PLANNING REF: PAA/86/19 – Angels Nursery, Barnham

PRE-APPLICATION RESPONSE - HOUSING STRATEGY AND ENABLING MANAGER ARUN DISTRICT COUNCIL

ANGEL'S NURSERY, BARNHAM - 2 BED APARTMENTS GROUND FLOOR PLAN AH

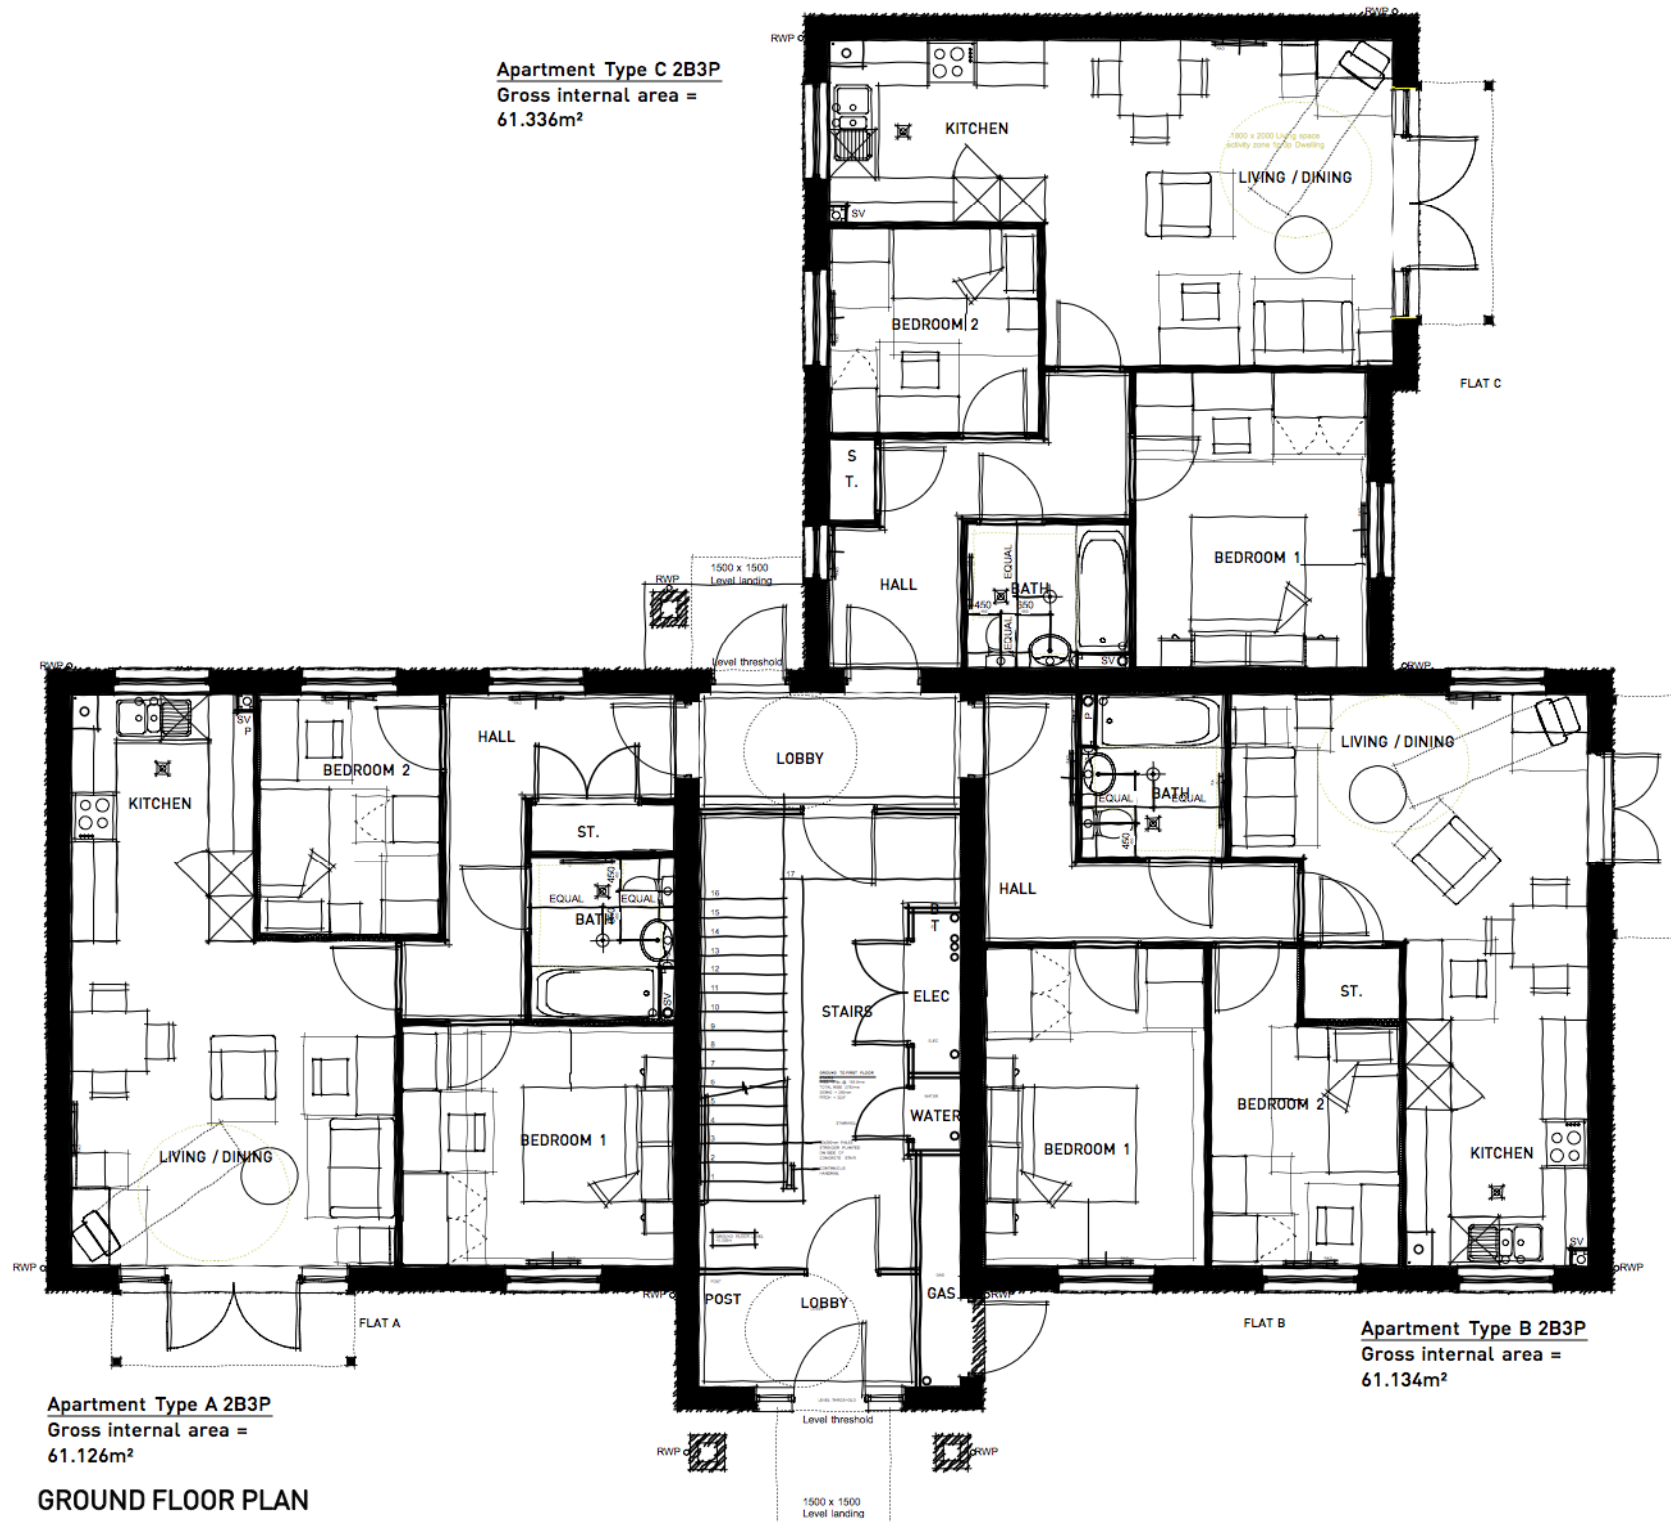
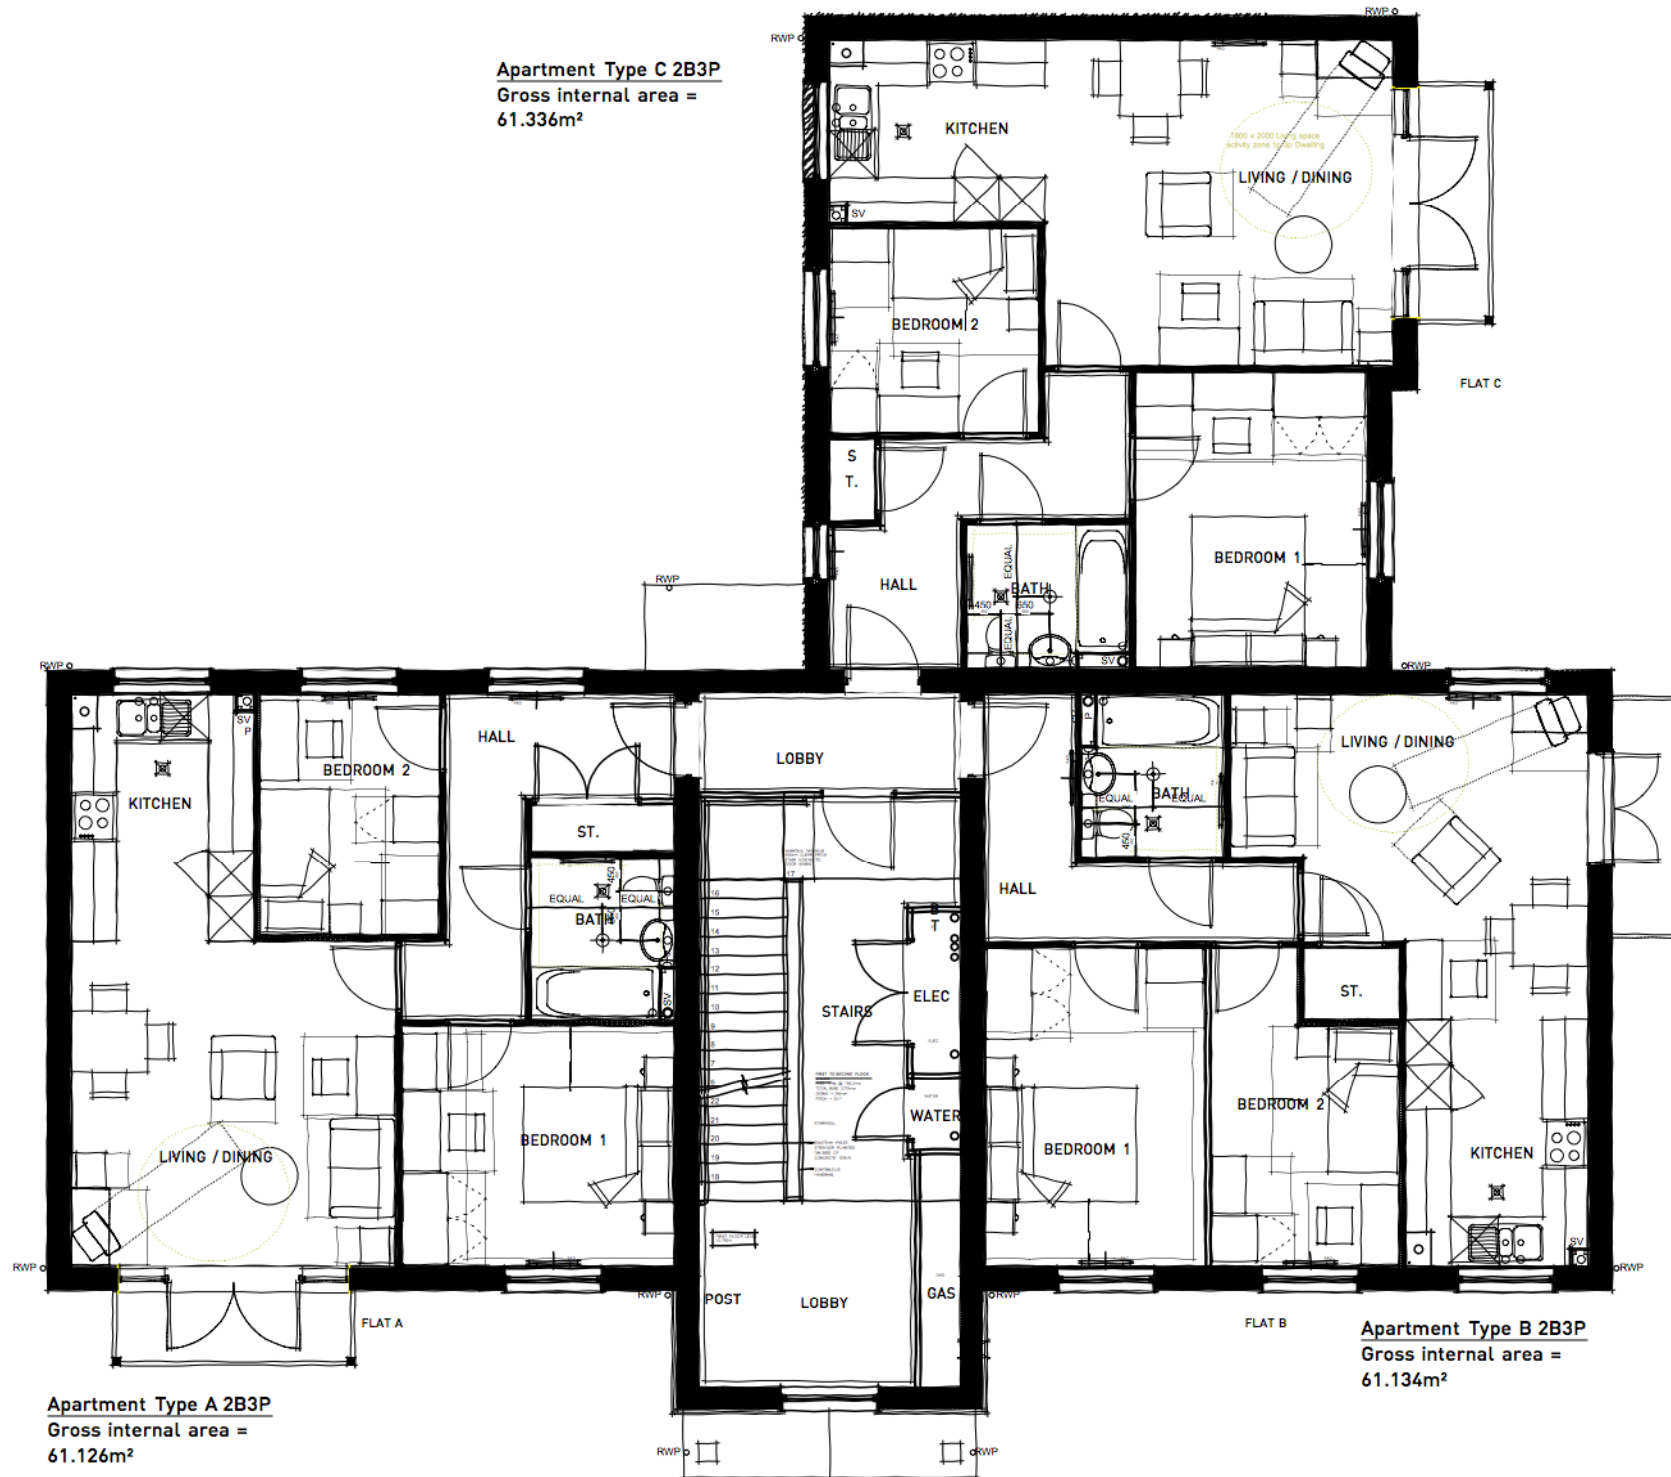
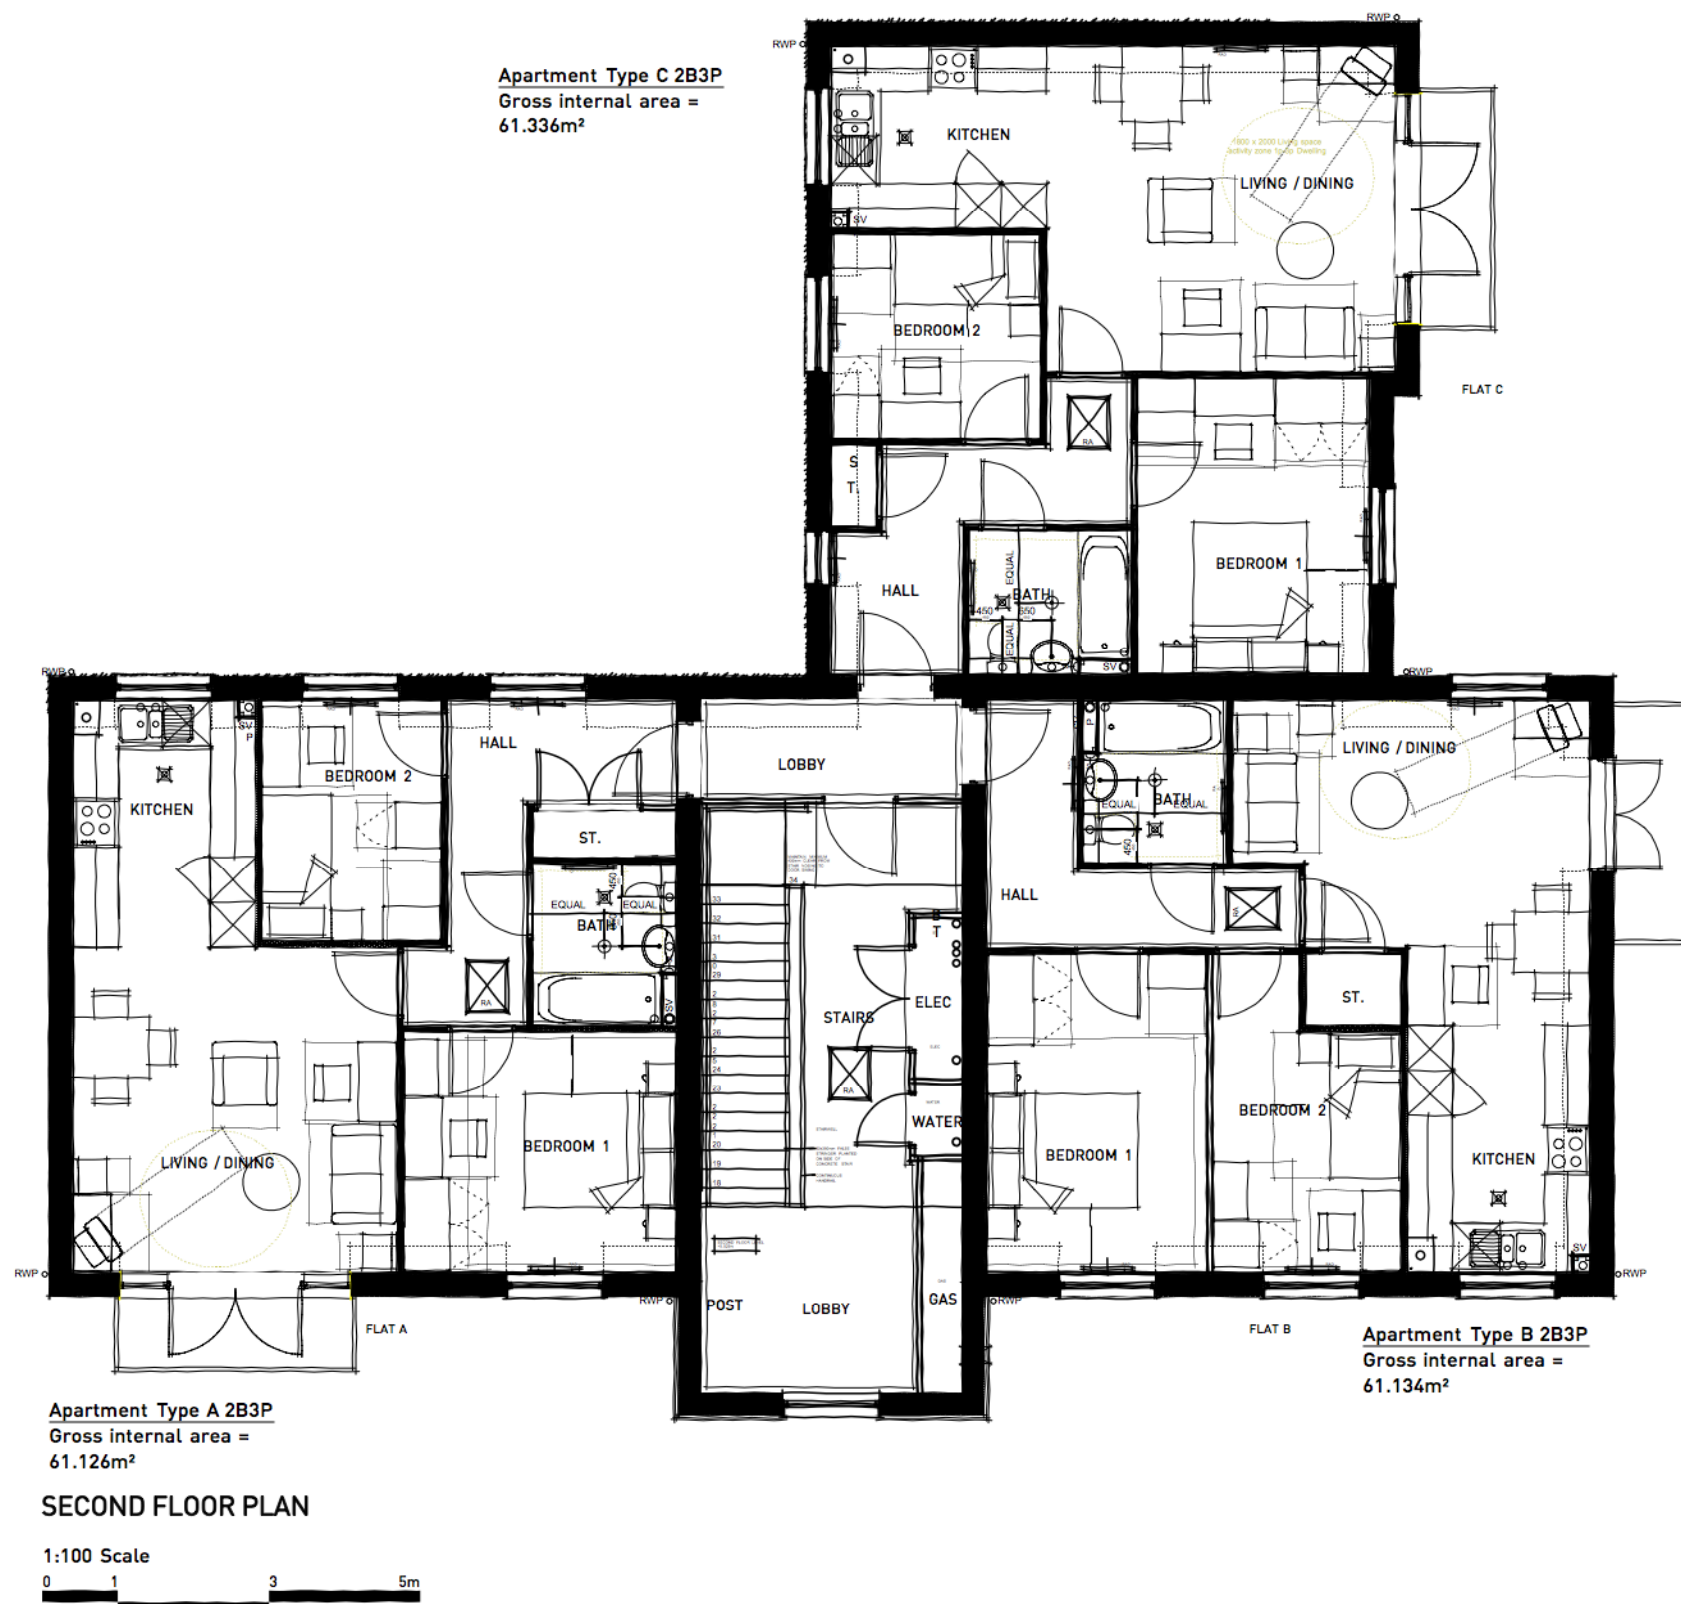
There is concern regarding the location of the 1 bed houses and 2 bed flats, in that it concentrates the majority of the affordable housing into one area. We would like to see consideration given to the relocation of one of these blocks.
